Mr Andrew Collingridge
Reed Cottage
Westergate Street
Westergate
PO20 3SQ

Please ask for: Ms Iqraa Malik
Email: iqraa.malik@terraquest.co.uk
Telephone: 01212341390
Our Ref: AL/54/20/HH
Your Ref:
Date: 14th July 2020

Application for Planning Permission for Works or Extension to a Dwelling

Development: Construction of garden shed and adjoining open potting area
Location: Reed Cottage Westergate Street Westergate PO20 3SQ

Reed Cottage, Westergate Street, Woodgate, Chichester, PO20 3SQ

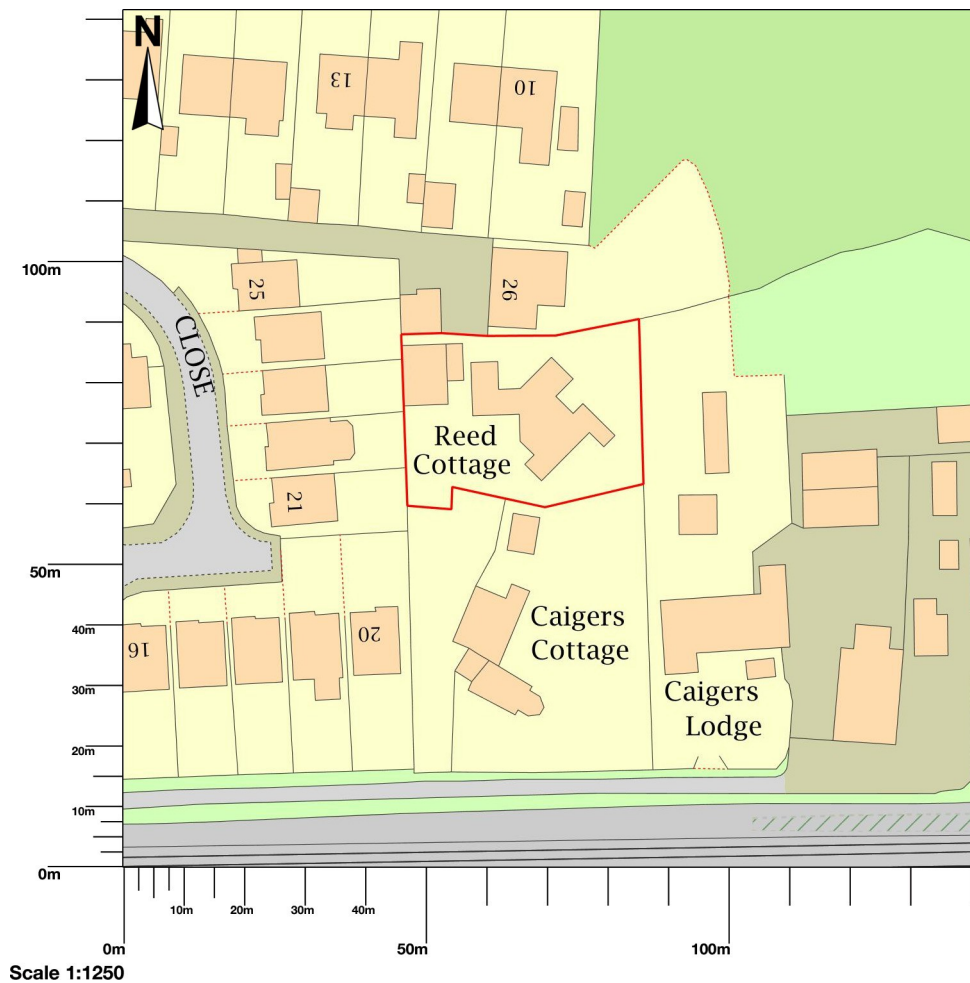
The size and shape of the proposed shed is inconsistent between the Location Plan and all other plans. Please amend.

Reed Cottage, Westergate Street, Woodgate, Chichester, PO20 3SQ

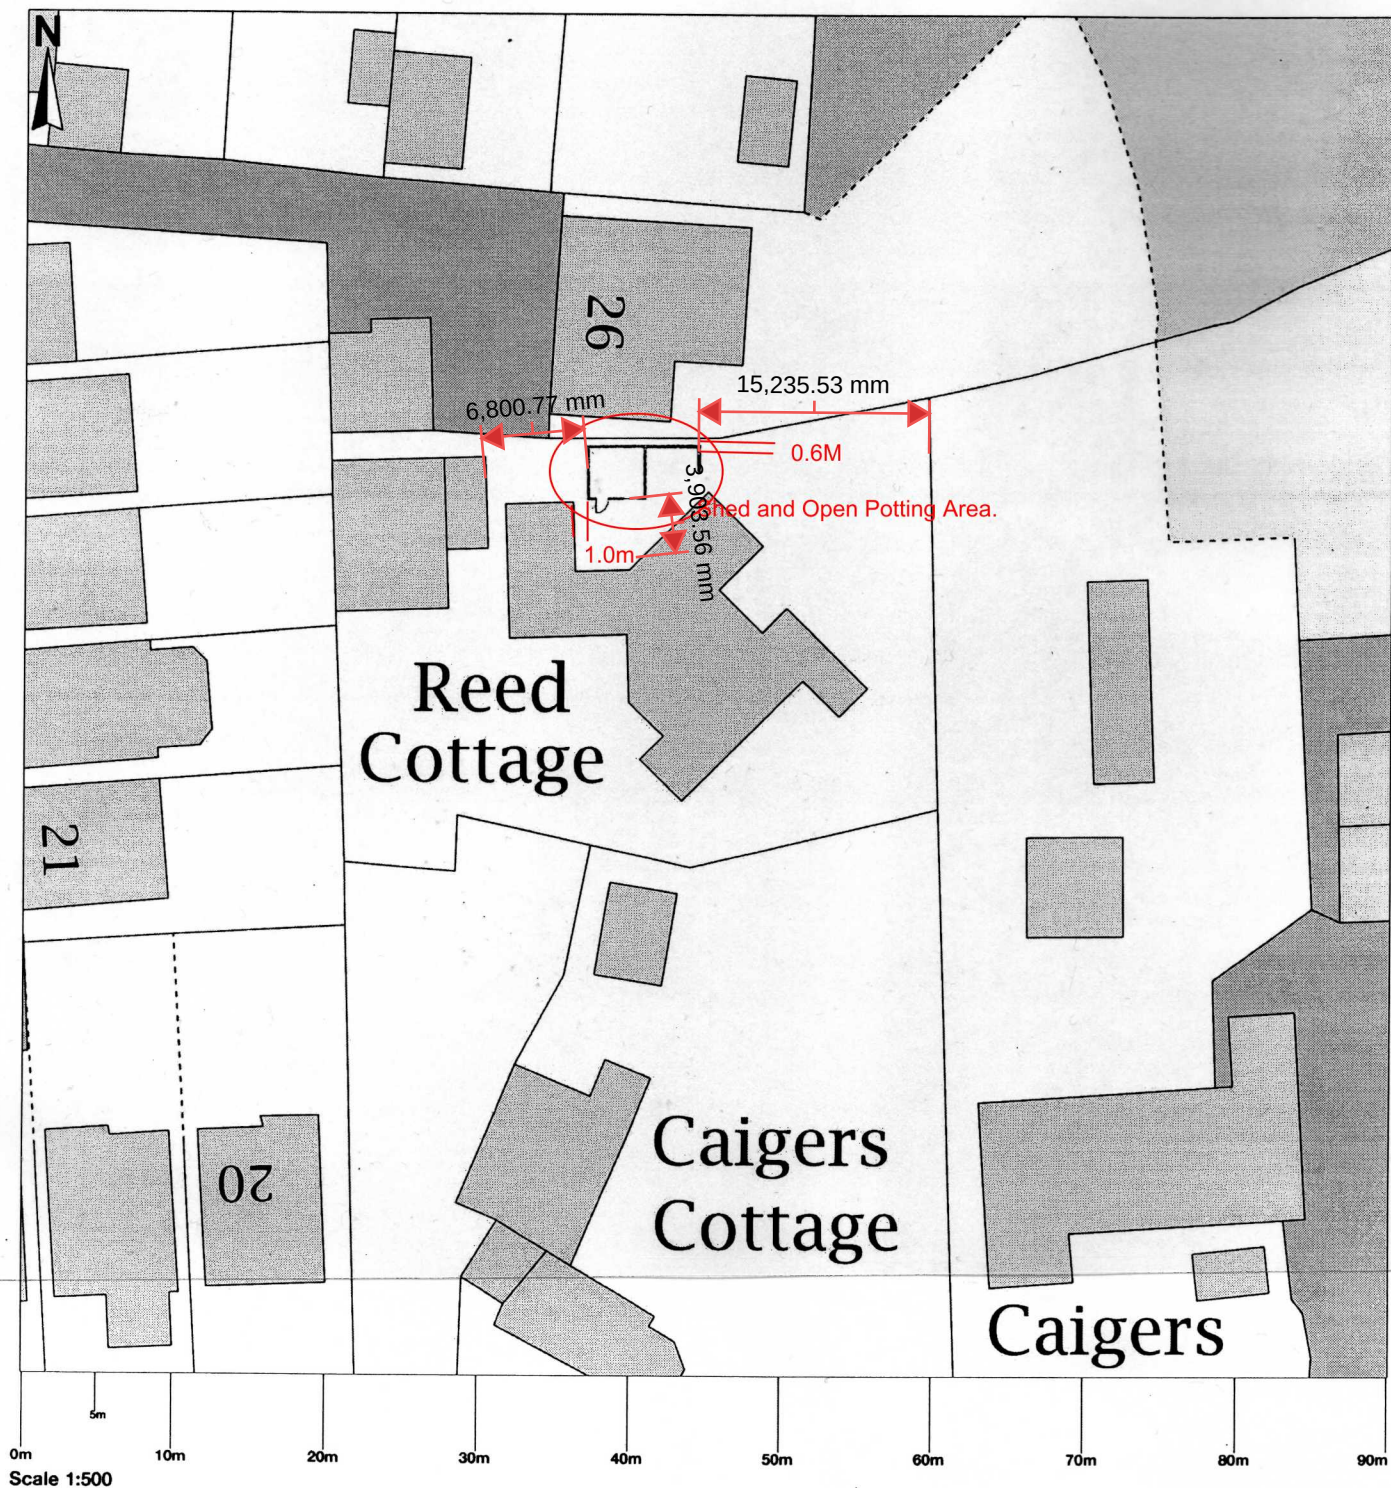
Please submit a copy of a block plan at a scale of 1:500. You are required to have clear dimensions from the proposed extension(s) to all site boundaries. Further details of what must be included on the plan can be found in the Validation Requirements List.

Reed Cottage : Shed and open potting area, Floor Plan

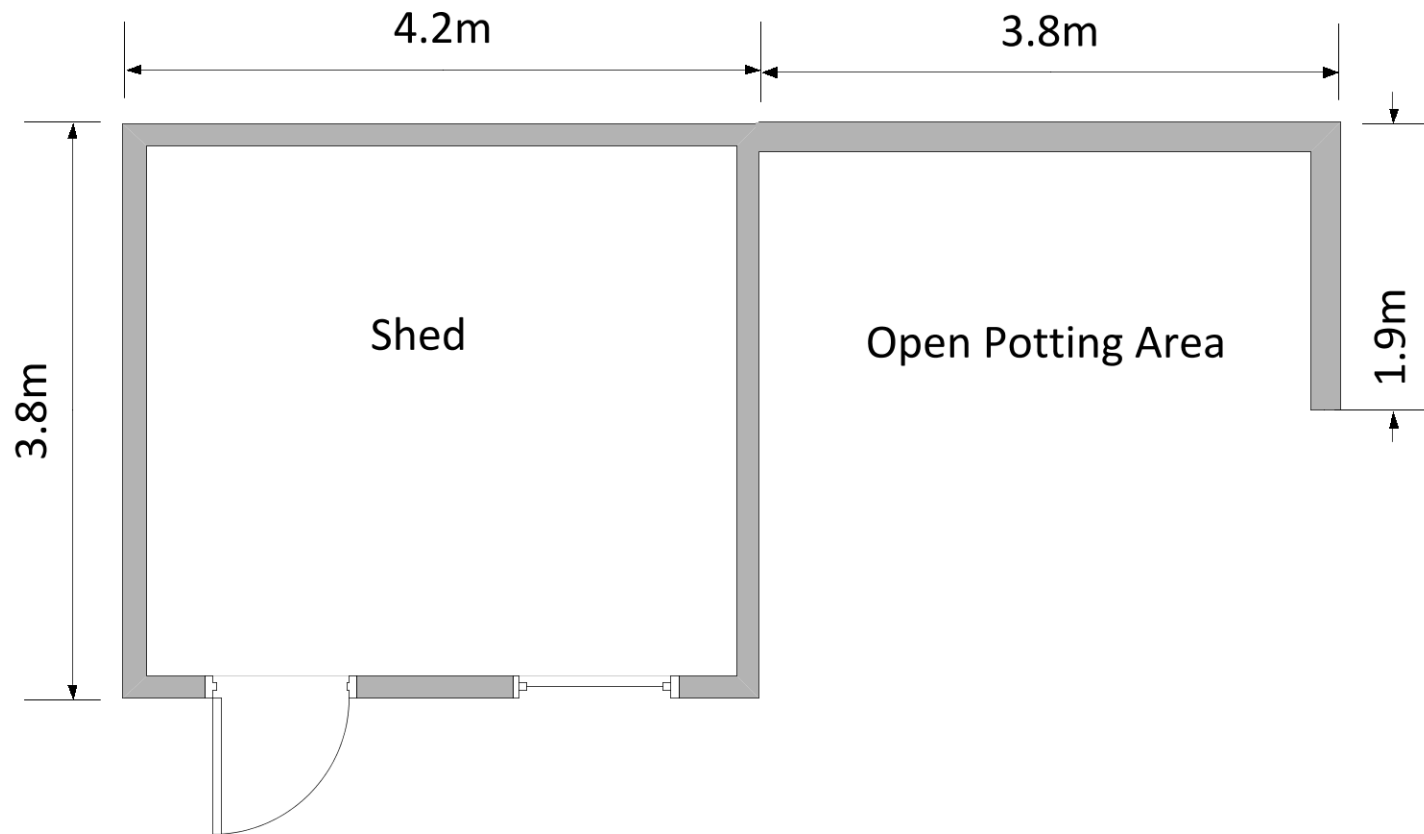
Please submit clearly labelled proposed floor plans with windows and door shown at a scale of 1:50 or 1:100. Further details can be found in the Validation Requirements List.

Reed Cottage : Shed and open potting area, Front Elevation
(South)

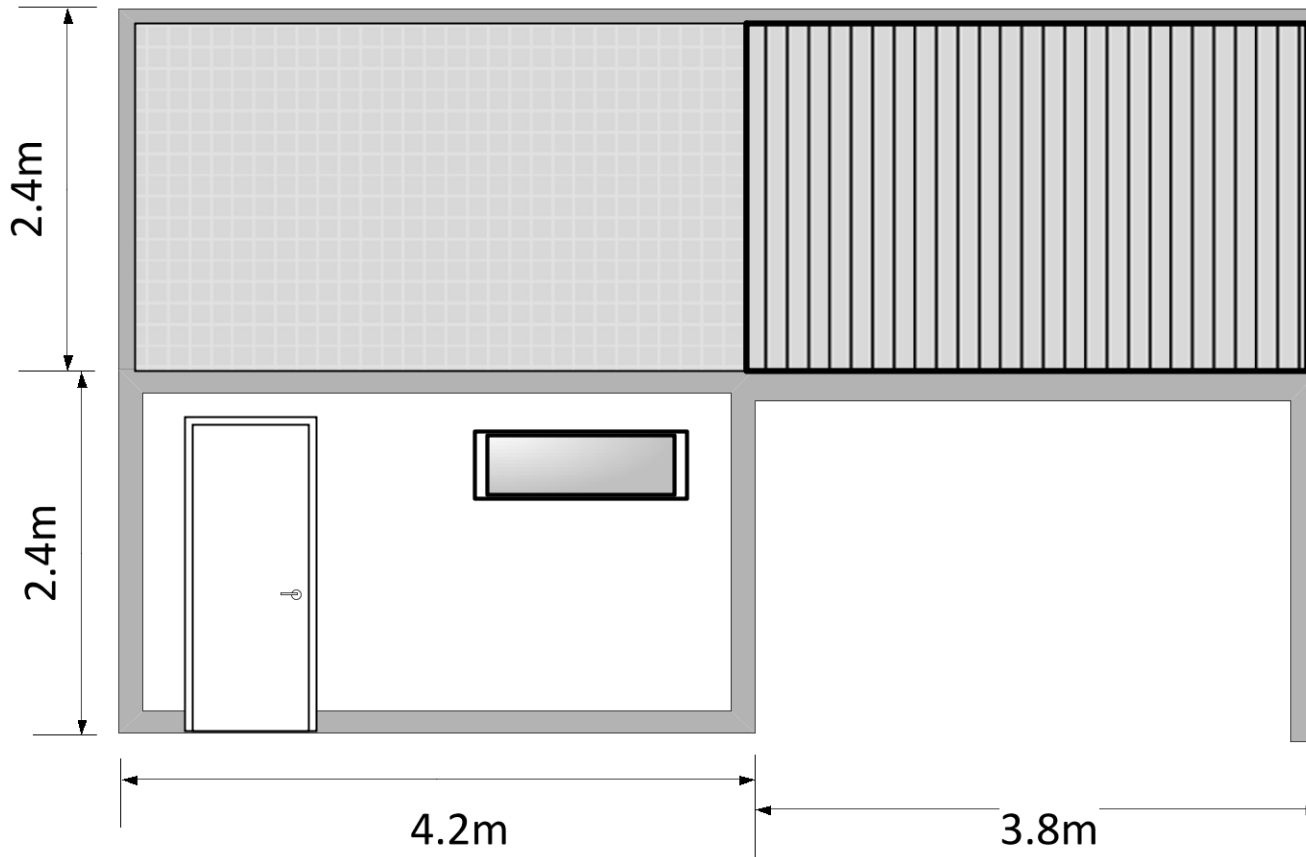
Please submit clearly labelled proposed elevations of all sides at a scale of 1:50 or 1:100. Further details can be found in the Validation Requirements List.
